From: Graham Evans
Sent: 09 January 2014 10:38
To: Planning.Responses
Cc: Neil Crowther
Subject: FW: Planning Consultation on: FG/128/13/

APPLICATION NO: FG/128/13/
Registered: 22nd November
2013

Site Address: Hangleton Farm - Lot 2 Hangleton Lane Ferring BN12 6PP

Description of Works: Alterations and change of use of buildings B through to K from equestrian/agricultural to animal rescue centre.

Figure 2: Noise Mitigation Measures

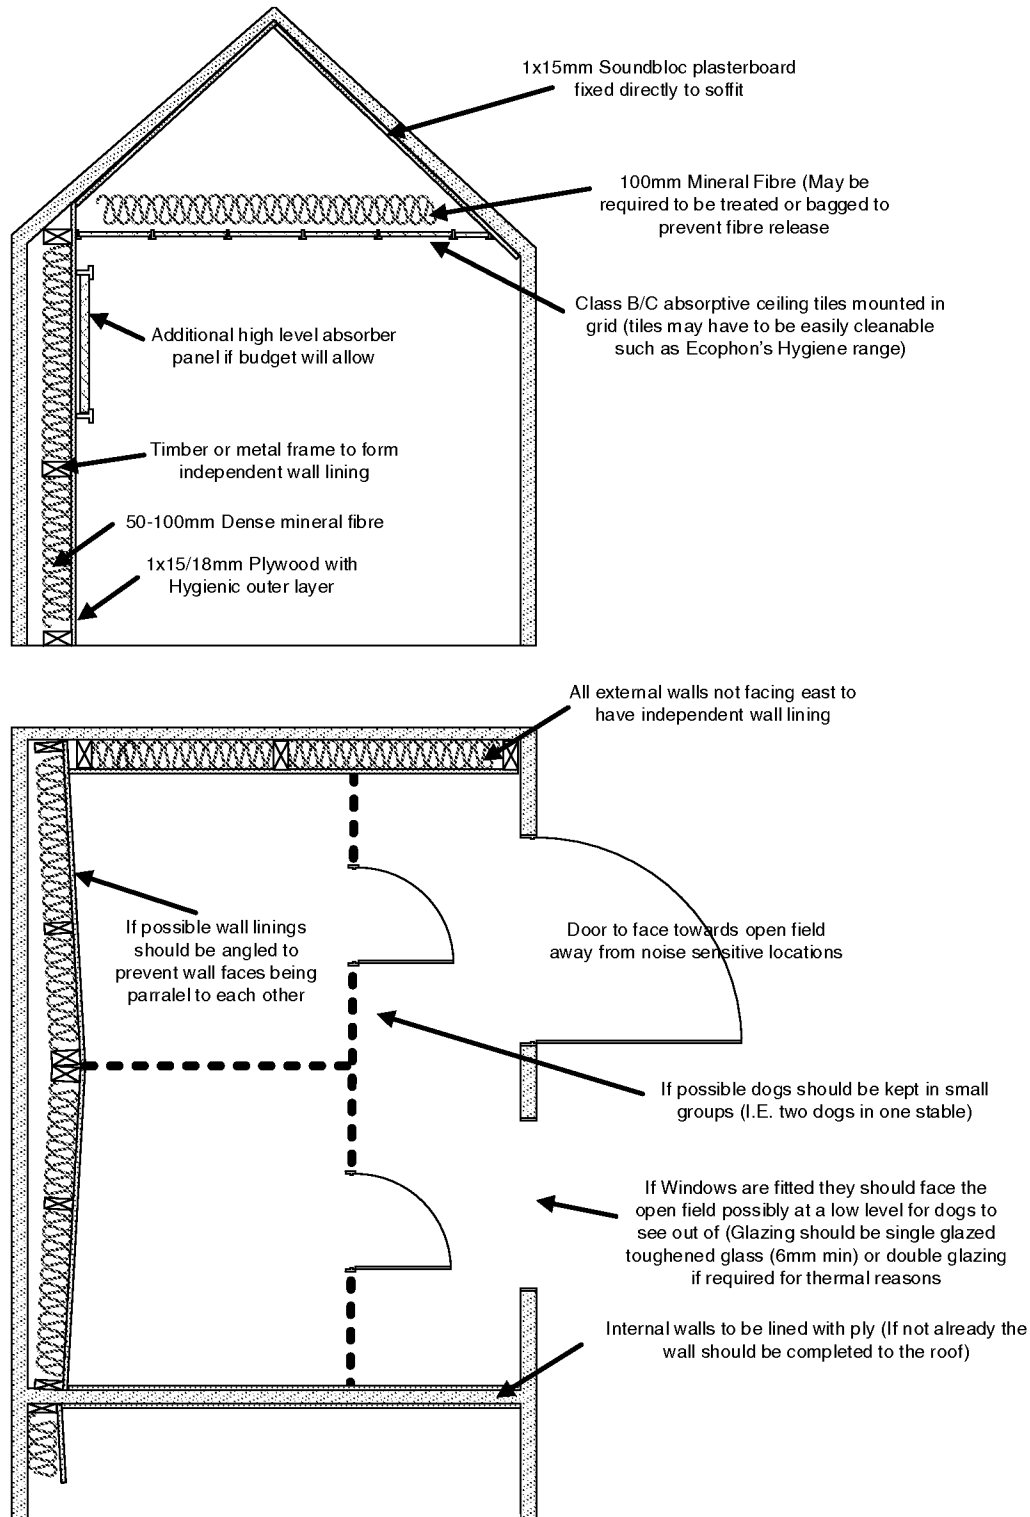
The application does not contain significant additional information to enable further comment in respect of the potential for noise to impact upon local amenity. Detailed design and layout of kennel blocks and runs are not provided, and no measures are identified to mitigate noise from external runs. I have concerns that long periods dogs barking (particularly in outside runs) may cause annoyance to residents at significant distance from the site.

Should you be minded to approve the application in the absence of such information I would recommend standard condition EHN 14, modified to include "control & ongoing management" of noise emanating from the site.

Although objective standards may not fully reflect the impact of noise from dog barking I would also recommend standard condition EHN 1 is applied to any approval. The noise assessment should be prepared in accordance with BS4142 and also compare predicted noise levels with World Health Organisation and BS8233 Noise Criteria at specified noise sensitive locations.
